A1 Birtley to Coal House
Scheme Number: TR010031
Addendum to Statement of Reasons

ADDENDUM TO STATEMENT OF REASONS

Rule Number:	Rule 8(1)(c)(i)
Planning Inspectorate Scheme Reference	TR010031
Application Document Reference	EXA/D4/003
Author:	A1 Birtley to Coal House Project Team, Highways England

Version	Date	Status of Version
Rev 0	20/04/2020	Deadline 4 Submission

KINGSWAY VIADUCT (JUNCTION 67)
PROPOSED CROSS SECTION B-B
SCALE 1:50

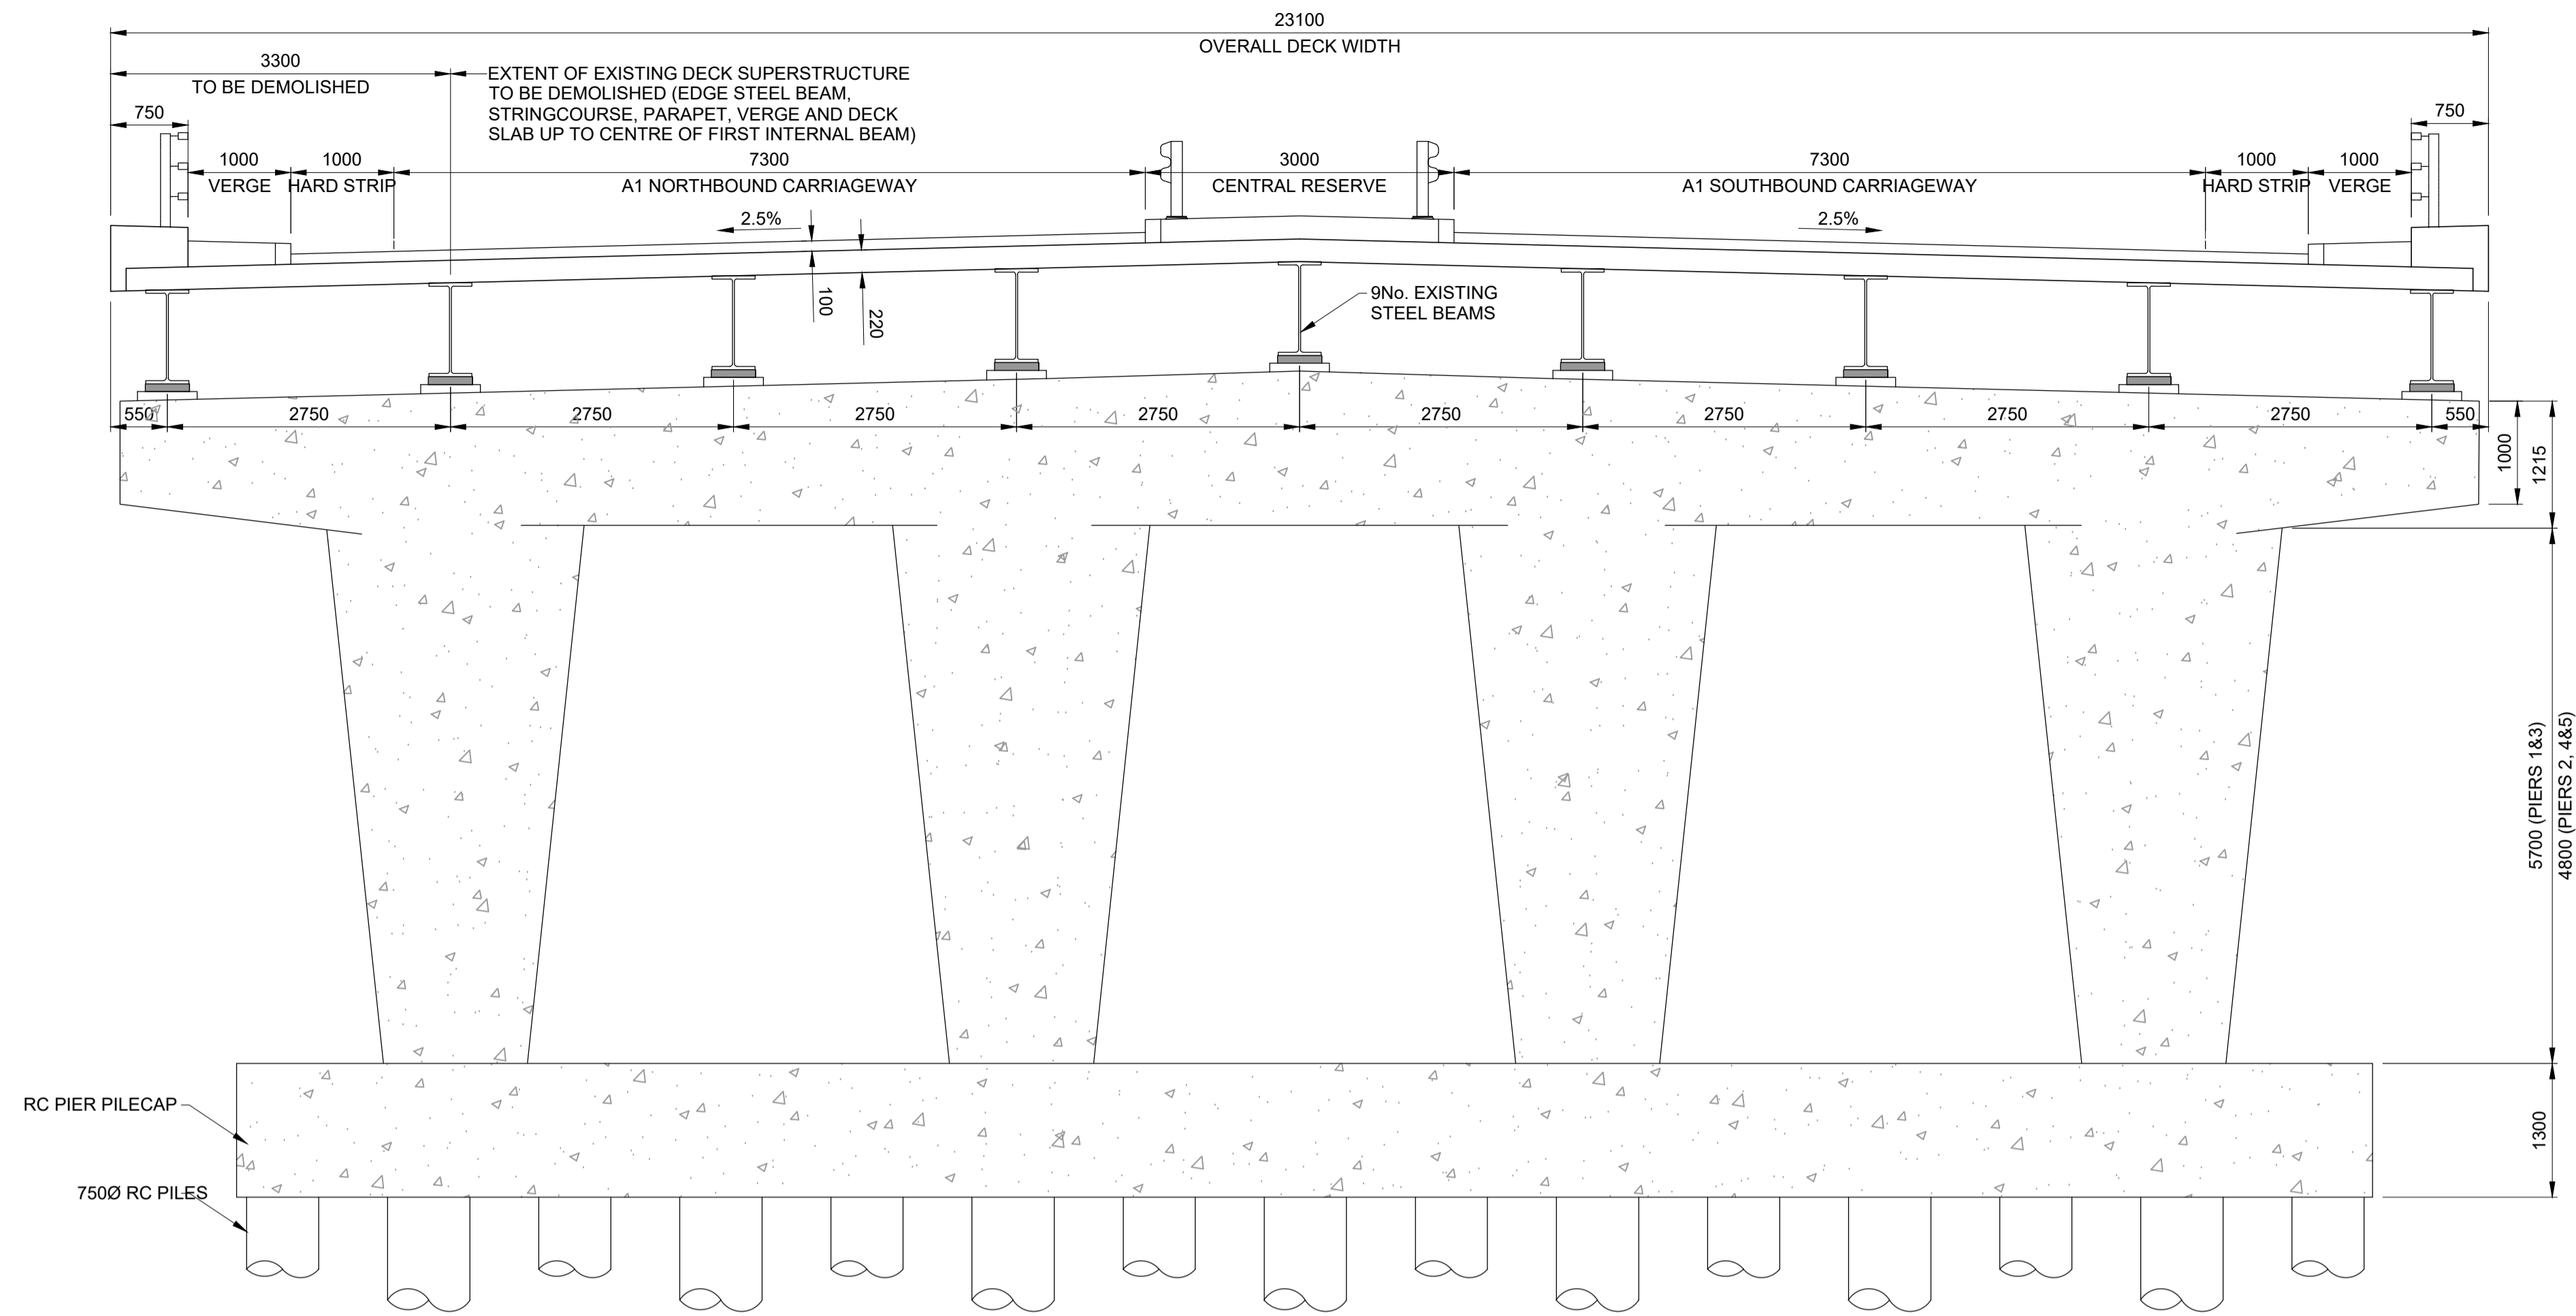
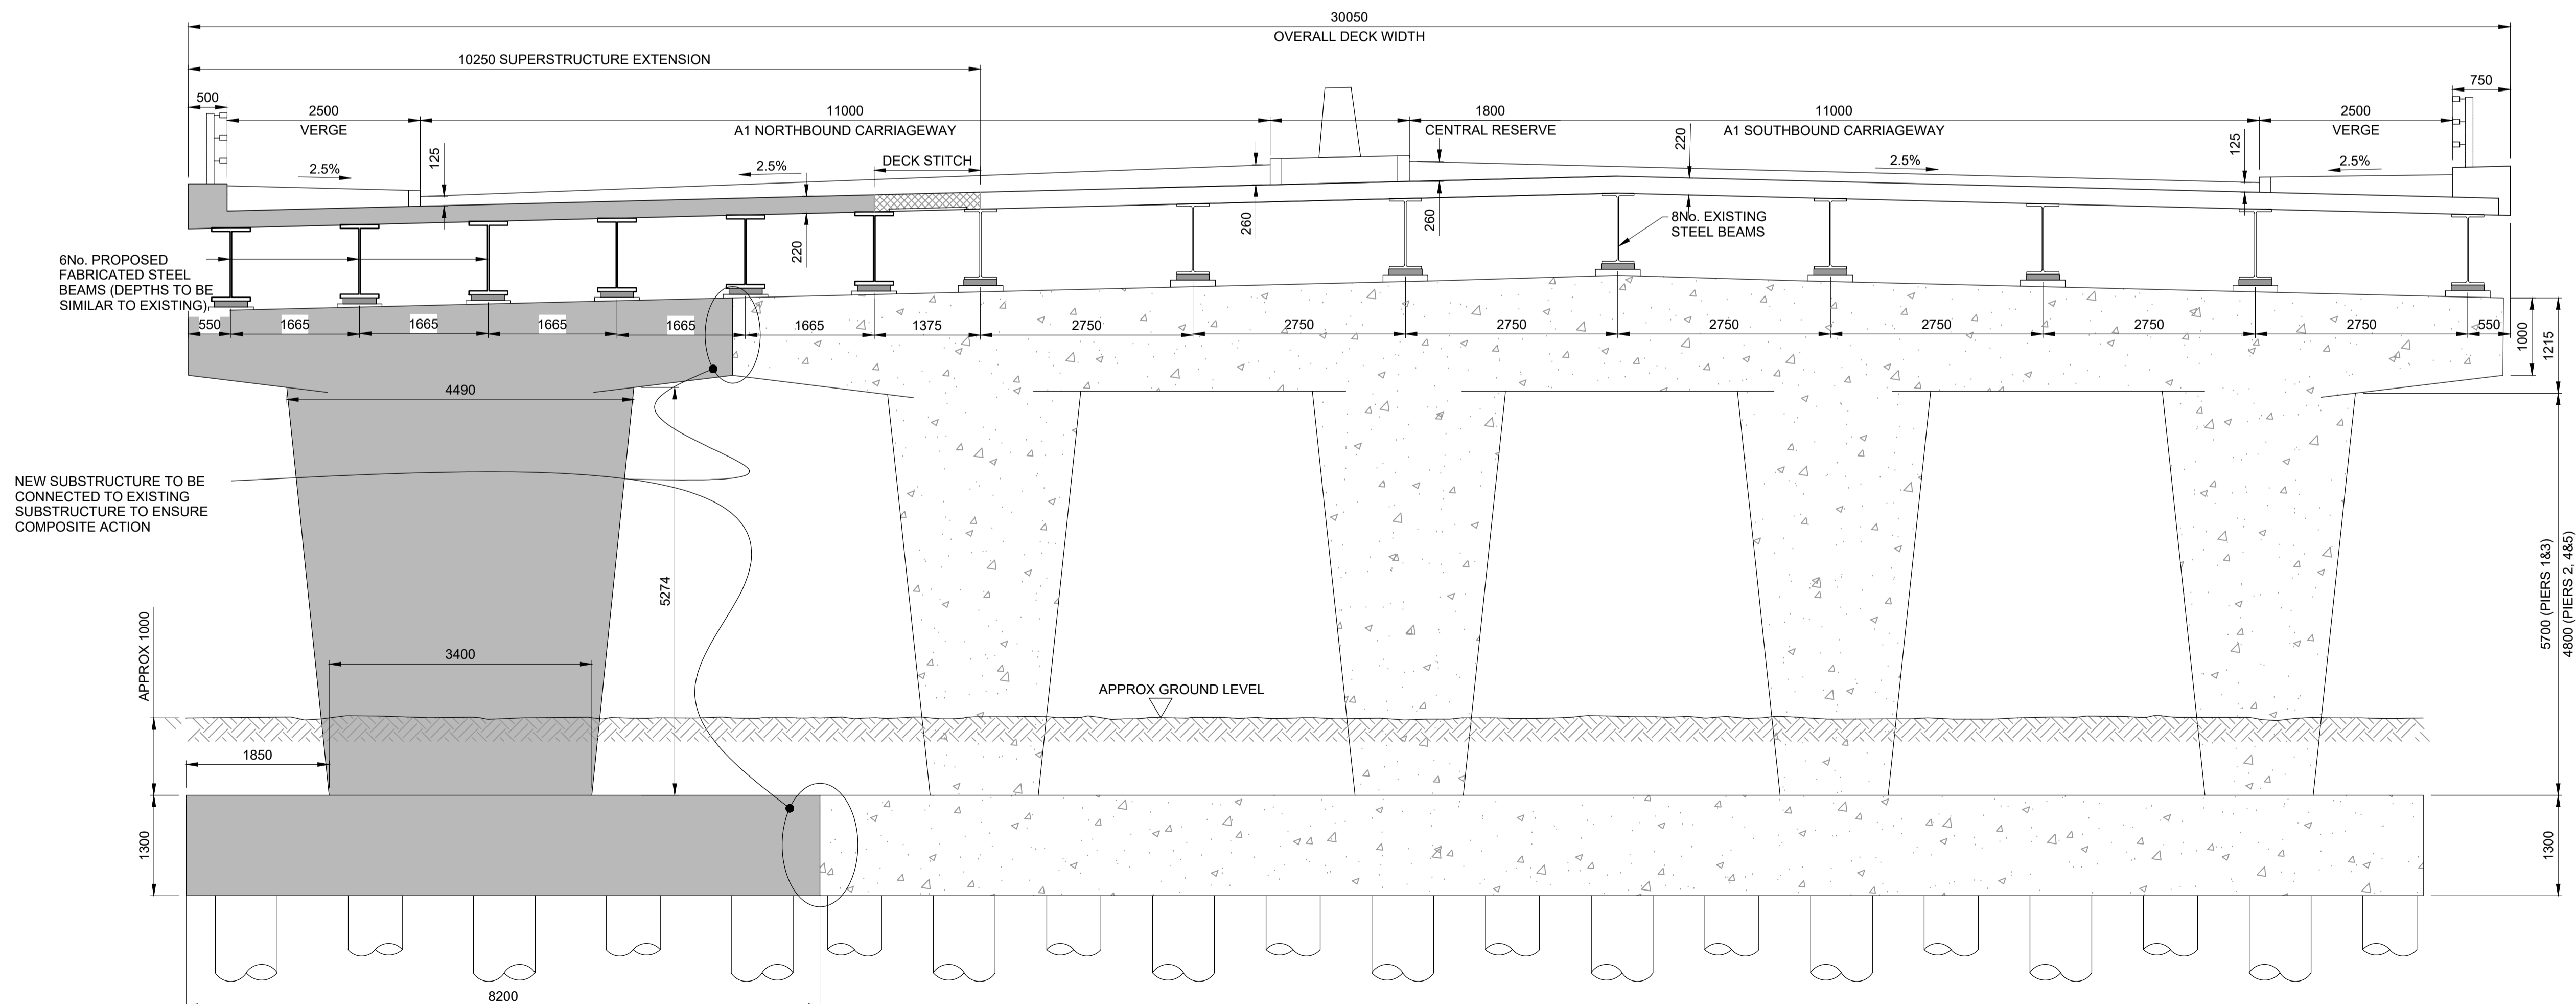
2. Narrower lane over Kingsway Viaduct at junction 67 (change 2): Providing flexibility as to the formation and the road layout of the Scheme to enable narrower lanes to be provided between the existing narrow lanes north of junction 67 and approximately chainage 11150 over Kingsway Viaduct at junction 67. The current Scheme proposes full width lanes. The new proposal is to allow narrower lanes extending over approximately 750m of the length of the Scheme to be introduced.

Section	Type	ID	Direction	Type	Role	Number
ZZ	DR	ZL	45012			3

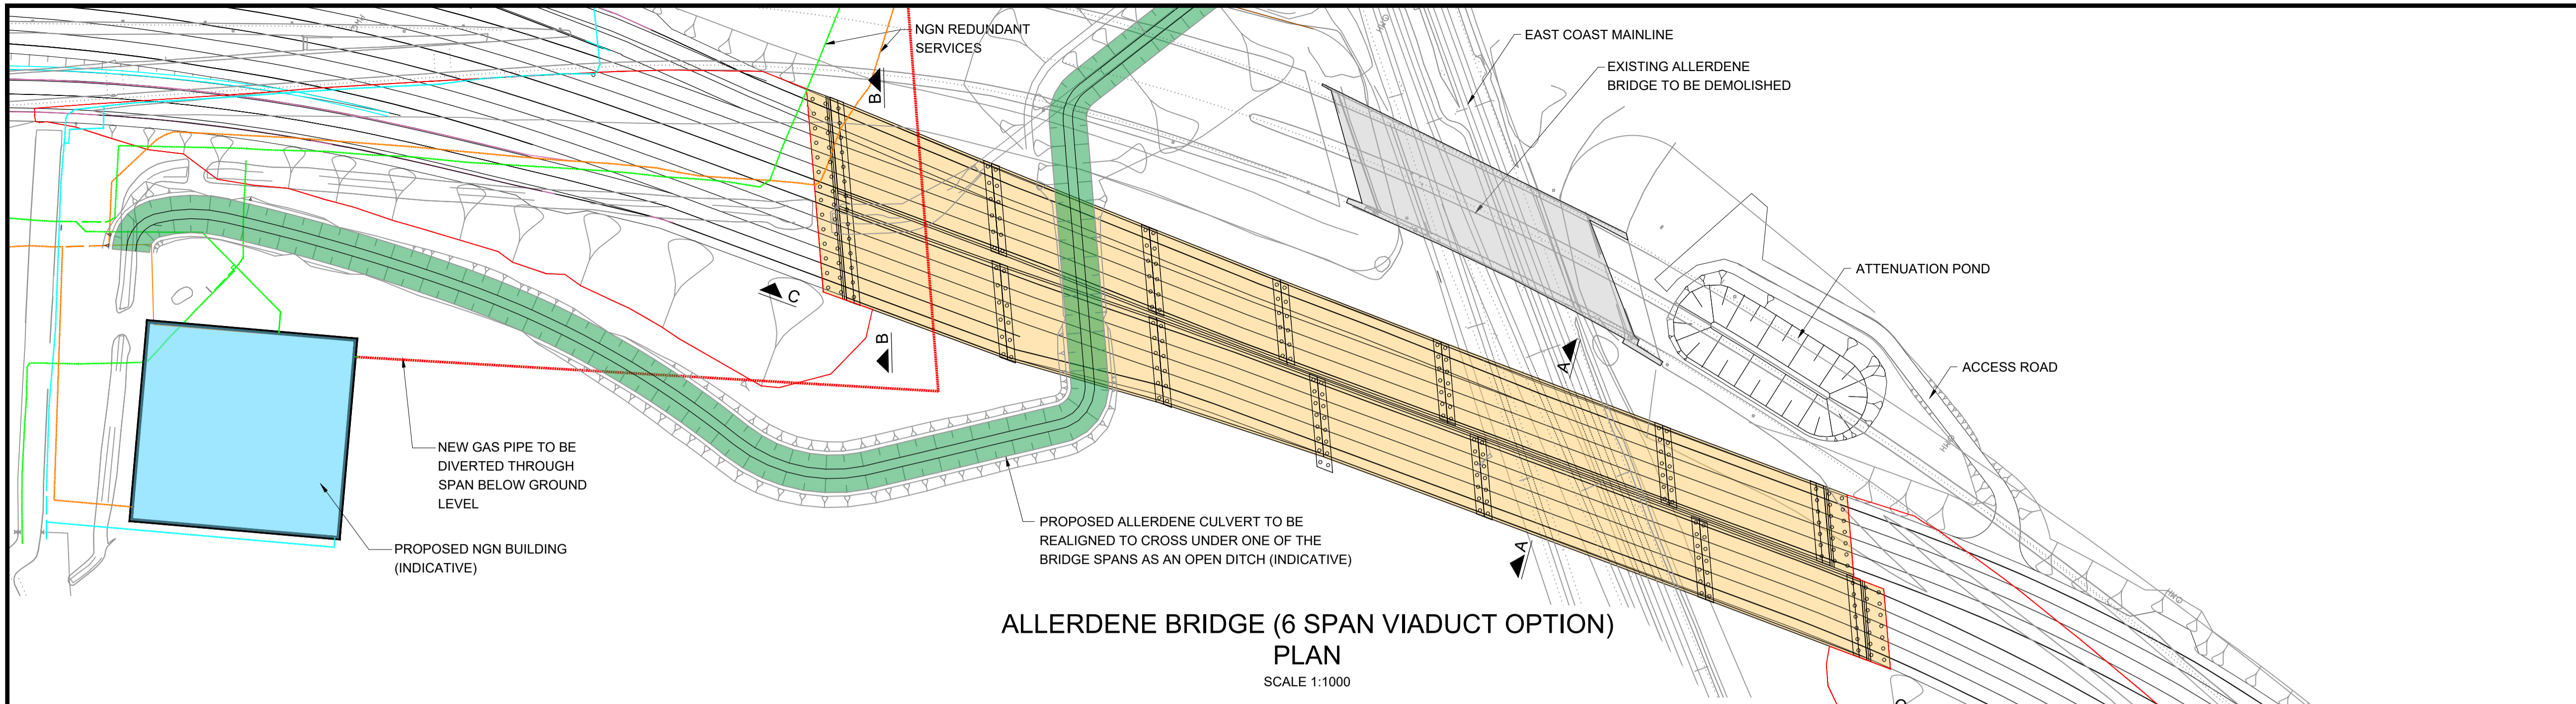
1. Allerdene three-span viaduct option (change 1): inclusion of further design flexibility in relation to the proposed replacement Allerdene Bridge over the East Coast Main Line. The draft DCO [REP2-044 and 045] currently allows for the replacement of Allerdene Bridge by a single span integral bridge or a 6/7-span viaduct. It is further proposed to enable the inclusion of a design for a 3-span viaduct under the DCO.

iii. *Construction of a 3 span viaduct structure (the 3 span viaduct option) supported by its abutments and reinforced by embankments. The 3-span viaduct option would comprise a central span (of approx. 65m in length), which would pass over the railway, with back spans to the east and west of "the railway (each approx. 45m in length). The proposed 3 span viaduct option would be supported on rigid piled foundations. The depths are expected to vary between 40m and 50m in length, all founded in competent rock.*

2.4.10A *3 Span Viaduct Option - the existing Allerdene Bridge would be replaced with a 3-span viaduct with a central span (of approx. 65m in length), which would pass over the railway, with back spans to the east and west of "the railway (each approx. 45m in length). The form of the superstructure would be a composite deck comprising a reinforced concrete deck slab atop steel girders as for the other options. The proposed form of the superstructure is the same as the 6/7 span viaduct option.*

2.4.10B *It is also proposed that reinforced soil is used to form the approach embankments to the east and west of the railway. This would result in slopes at a maximum angle of 60 degrees (in contrast to the 1 (vertical) in 3 (horizontal) slope under the 6/7 span viaduct option).*
